Ribble Valley Borough Council  
Housing & Development Control

Application no: **3/2021/0603**

Address: **Dene House 8 Longridge Road Hurst Green BB7 9QP**

Proposal: **Construction of vehicle crossing (drop kerb) onto Longridge Road providing an alternative means of vehicle access to the applicant's land to allow United Utilities to access, repair and future maintenance to the existing rising sewer main between The Dene and Longridge Road.**

Internal Parking Area & Drainage

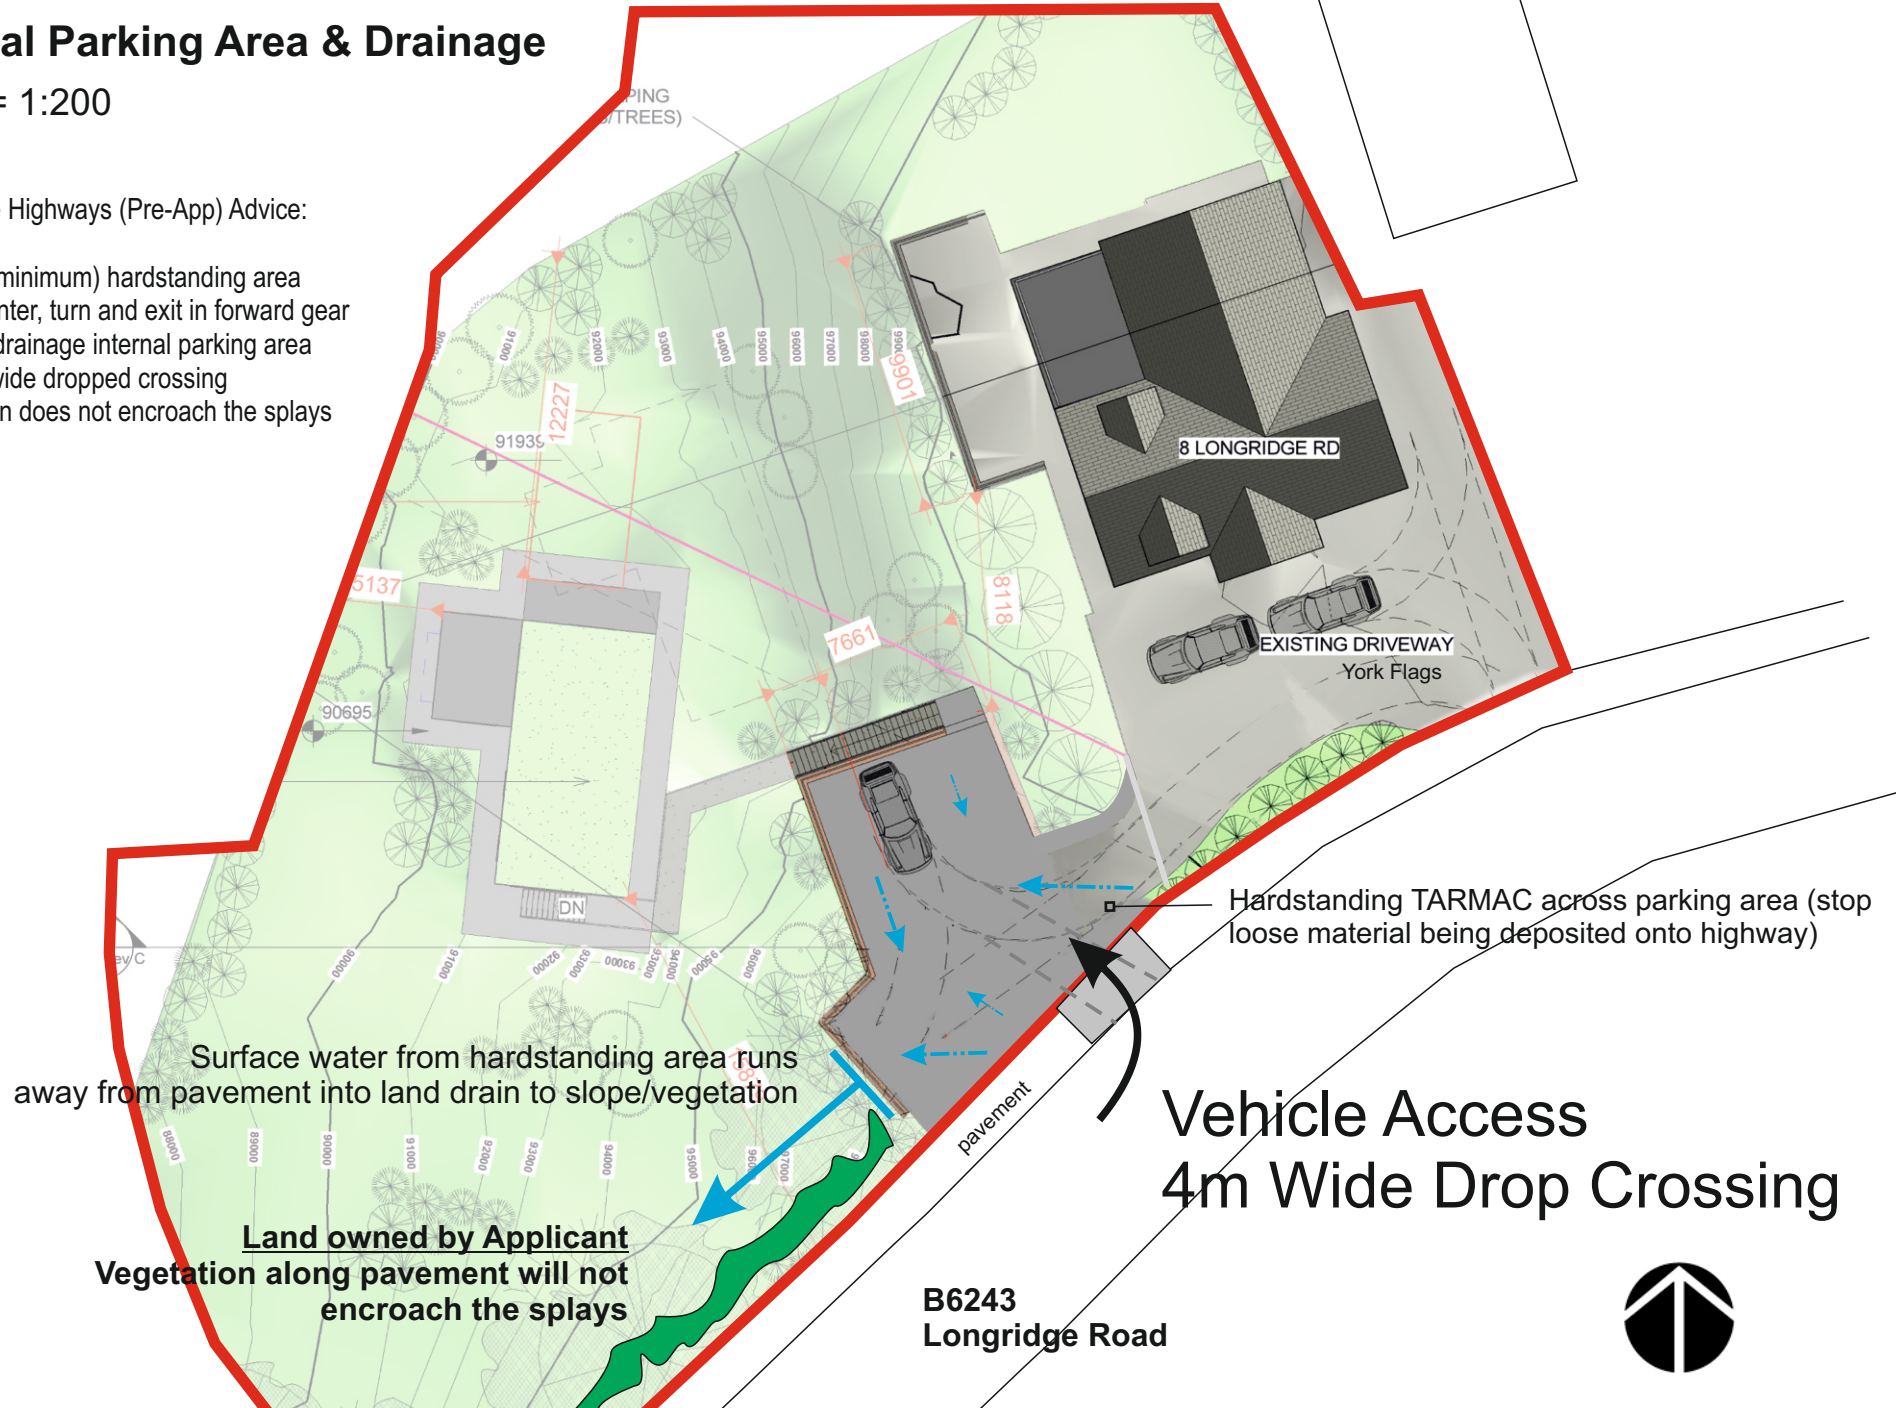
The LHA have reviewed the drawing titled "Internal Parking Area and Drainage" and understands that the access width complies with the LHAs guidance.

The LHA have reviewed the drawing titled "Internal Parking Area and Drainage" and are satisfied the site provides adequate parking and turning facilities. Therefore, the LHA have no objection to the proposal.

1. No part of the development hereby permitted shall be occupied until such time as the access arrangements shown on the drawing titled "Internal Parking Area and Drainage" have been implemented in full.

4. The development hereby permitted shall not be occupied until such time as the parking and turning facilities have been implemented in accordance with the drawing titled "Internal Parking Area and Drainage". Thereafter the onsite parking provision shall be so maintained in perpetuity.

5. The development hereby permitted shall not be occupied until such time as the access drive (and any turning space) has been surfaced with tarmacadam, or similar hard bound material (not loose aggregate) for a distance of at least 5 metres behind the highway boundary and, once provided, shall be so maintained in perpetuity.

Scale Plan: Visibility Splays

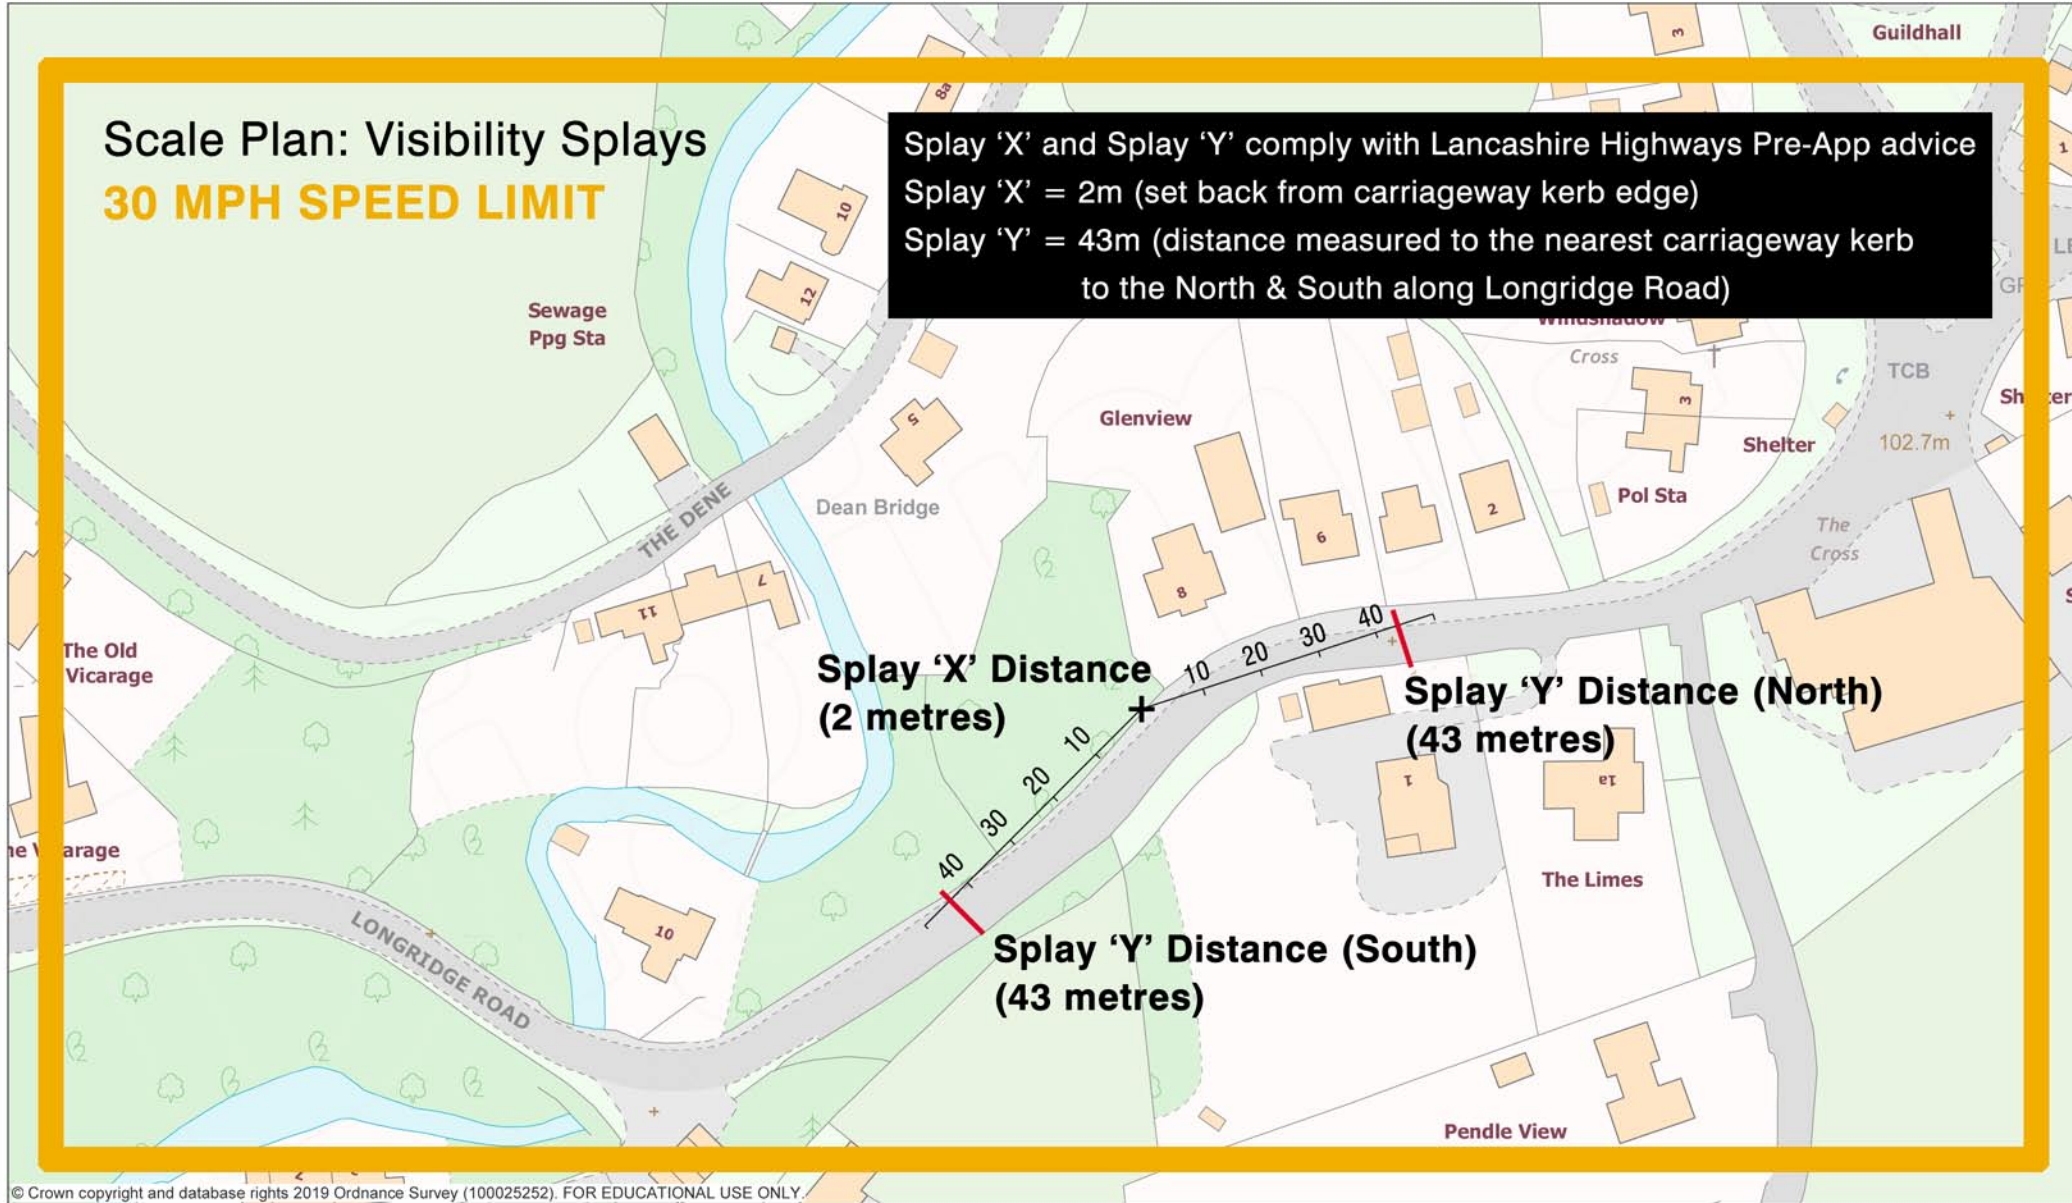
The Applicant has also submitted a drawing titled "Visibility Splay," which shows the site is able to achieve the minimum vehicular visibility splays of 2m by 43m in both directions, which complies with the LHAs guidance.

2. No part of the development hereby permitted shall be occupied until such time as 1.0 metre by 1.0 metre pedestrian visibility splays have been provided on the highway boundary on both sides of the access with nothing within those splays higher than 1 metres above the level of the adjacent footway/verge/highway and, once provided, shall be so maintained in perpetuity.

3. Nothing shall be erected, retained, planted and / or allowed to grow at or above a height of 1 metres above the nearside carriageway level which would obstruct the visibility splay. The visibility splays shall be maintained free of obstruction at all times thereafter for the lifetime of the development.
